Application for a non-material amendment following a grant of planning permission

DORMERS TO FRONT & REAR

2024/93539

LARGER LANDING WINDOW TO REAR

Drg No 24 | 147 Rev A

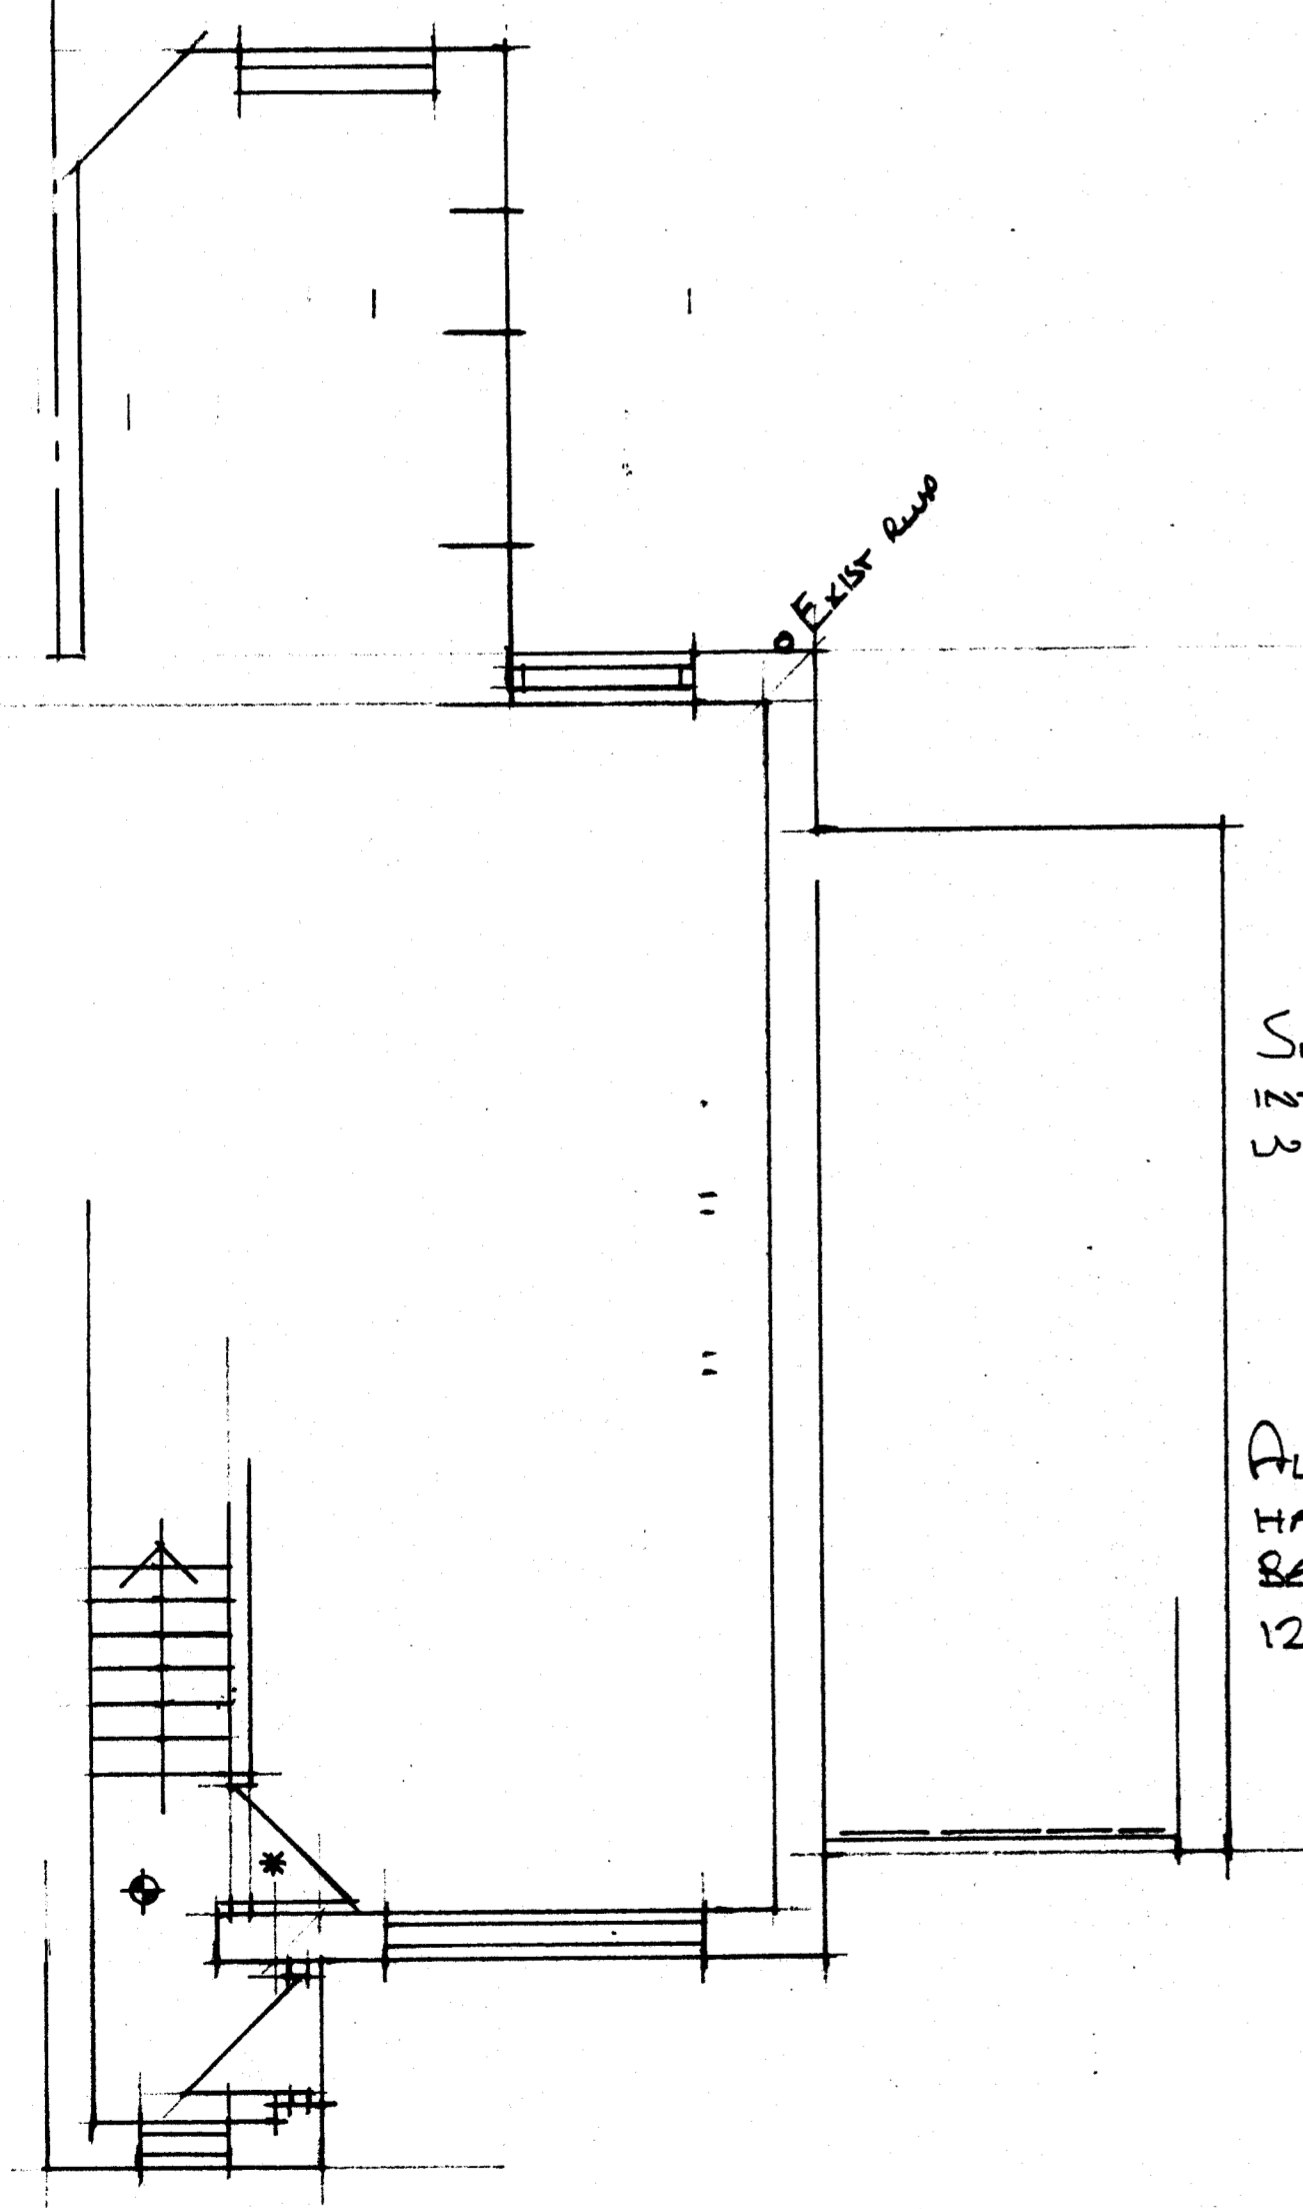
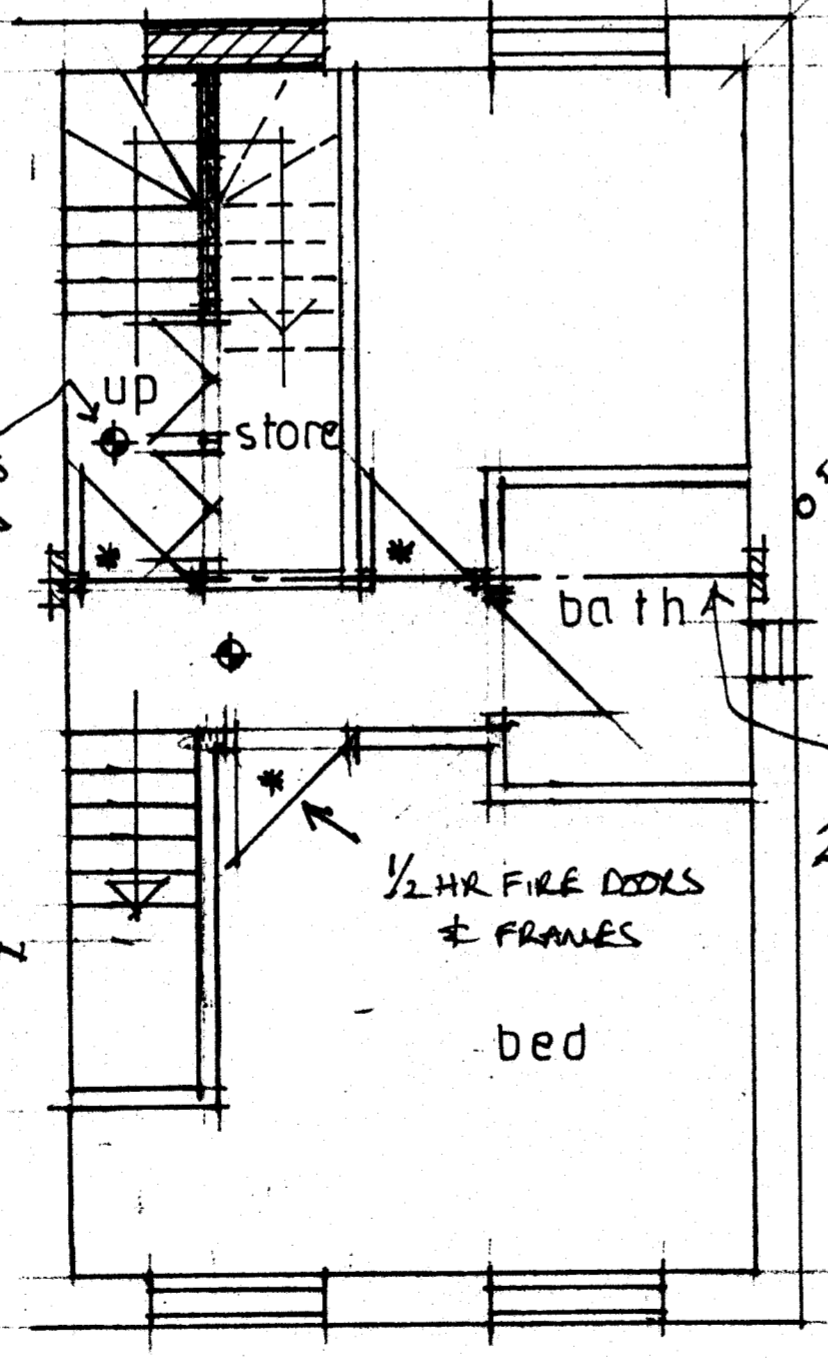
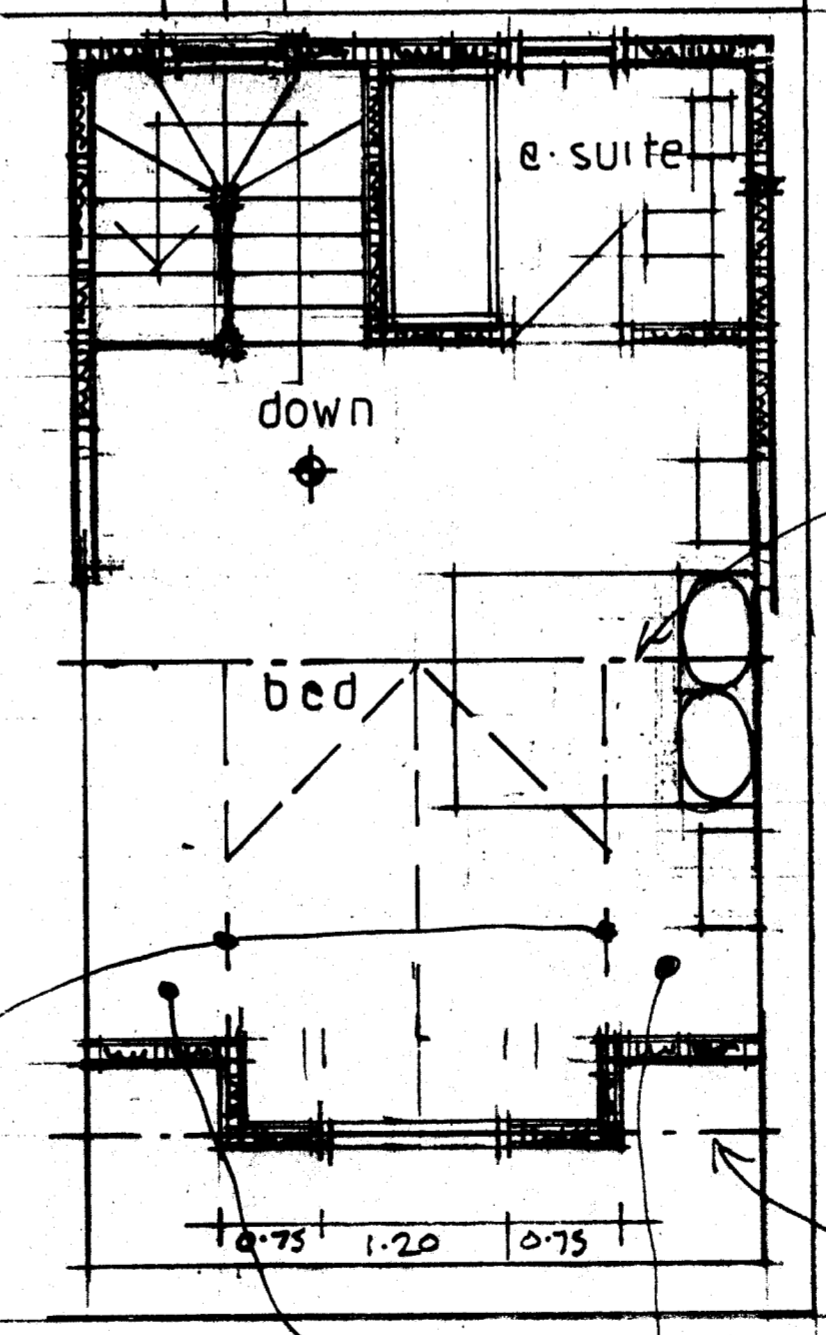
ADDITIONAL LIGHT INTO STAIRS / LANDING AREA
